Engineers Comments Regarding Surface Water Drainage

| Application Reference: | WA/109/24/OUT | Reviewer Reference: | ADC/PC |
| Site Name: | Sussex Business Village Lake Lane Barnham PO22 0AL | | |
| Application Description: | Outline planning permission for 3 No. attached dwellings with associated gardens, access and parking. This application is in CIL zone 3 (CIL liable as new dwellings) and is a dual parish application with Yapton Parish Council. | | |

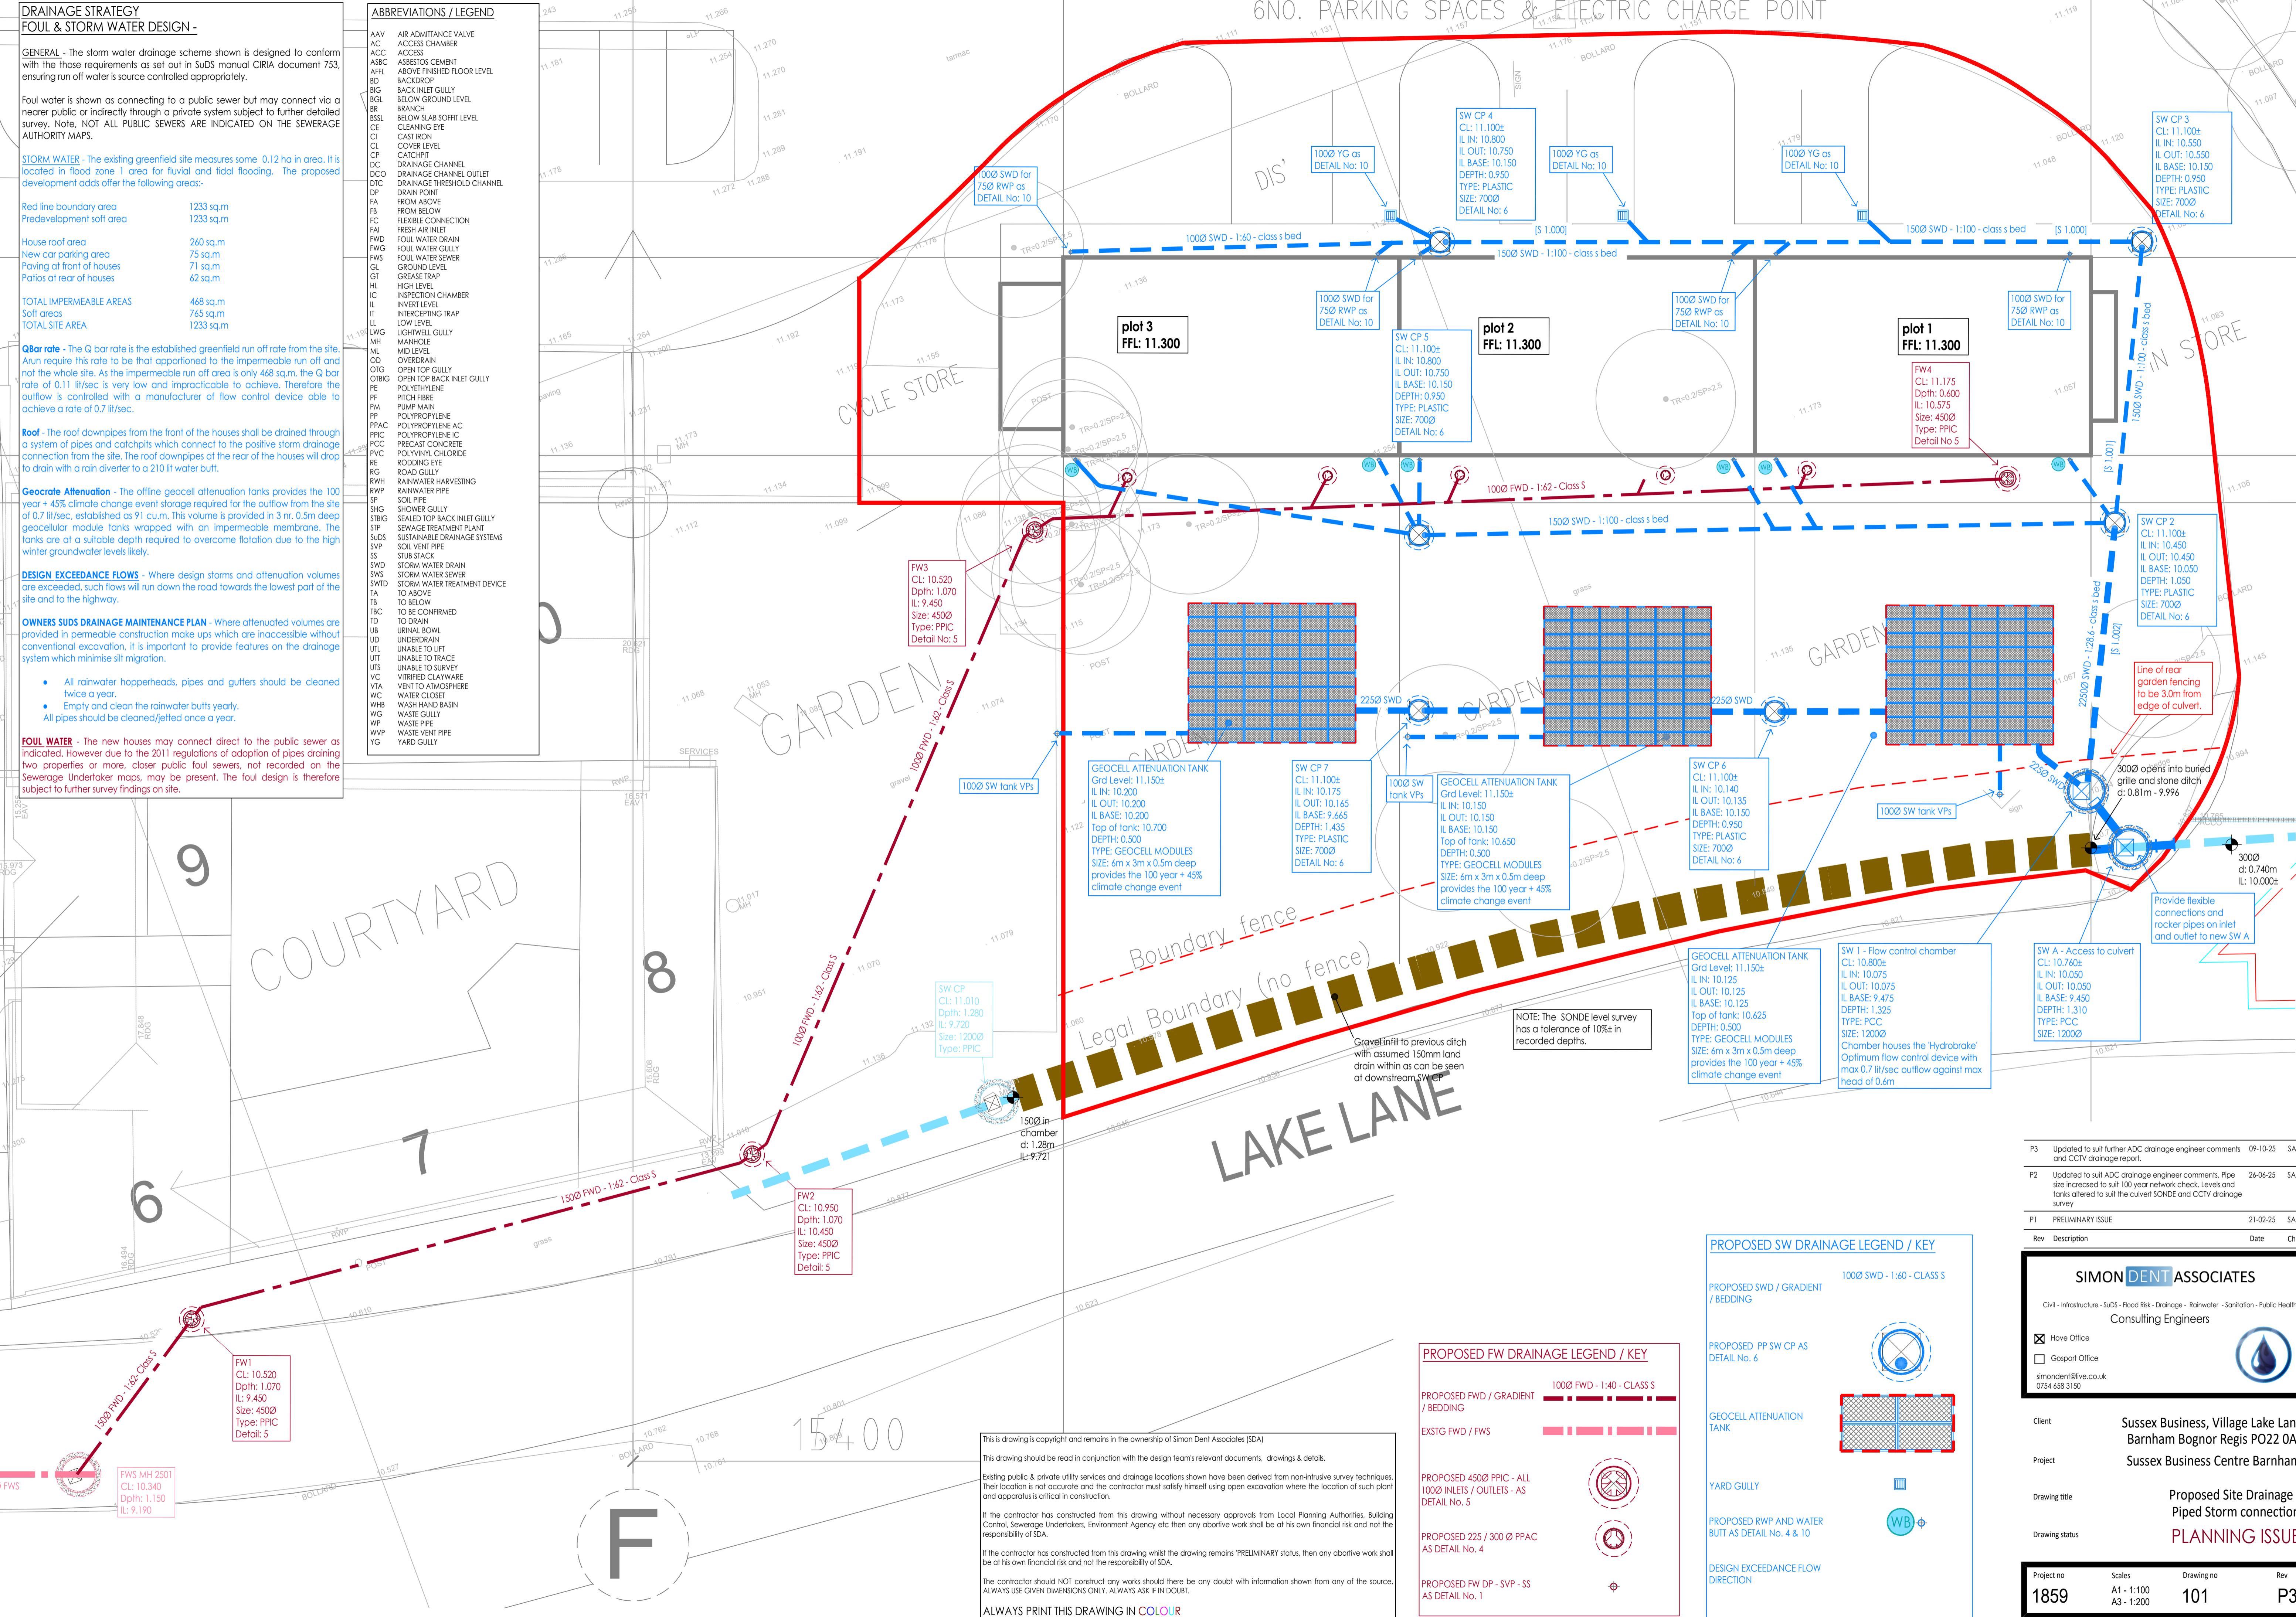
In terms of the proposed connection level to the culvert, it is unclear as to whether a soffit to soffit connection is being achieved. The short length of 100mm diameter pipe downstream of flow control chamber SW 1 requires a positive gradient (currently laid flat). The existing culvert is shown as 225mm diameter on the plan but the CCTV survey indicates it as 300mm diameter. Which is correct needs to be verified and the plan adjusted if necessary. The specified overall depth of manhole SW 1 is incorrect (should be 1.3 metres as opposed to 2 metres) and should be corrected. Based upon the estimated culvert invert level of 10.000 downstream of the proposed connection , it appears that a soffit to soffit connection is not being achieved. It will need to be clearly demonstrated that it is possible. The applicant may wish to consider utilising a pipe diameter equal to the culvert diameter, for the short length of pipe downstream of chamber SW 1 to help achieve the requirement. **Resolved – proposed pipe diameter between chambers SW1 & SWA confirmed as 300mm in email dated 9.10.25.**

The hydraulic modelling calculations for the storage tanks specifies an orifice flow control as opposed to a hydrobrake (as detailed on the drawings). Please correct the calculations. A hydrobrake will also provide improved performance over an orifice and may impact the output. Spare volume within the crate structures is approx. 10m3. The pipework and manholes will provide additional storage volume, together with further storage as a result of addressing water treatment requirements (ie. permeable paving, etc). Therefore, the storage proposed currently and to be increased at a later date, would seem reasonable. **Explanation in respect to orifice/hydrobrake flow control included in email dated 9.10.25.**

2. A revised plan showing that a minimum 3 metres distance is achieved between the edge of the existing culvert and any structure/boundary fencing. This currently measures less than 3 metres. **Plan adjusted.**
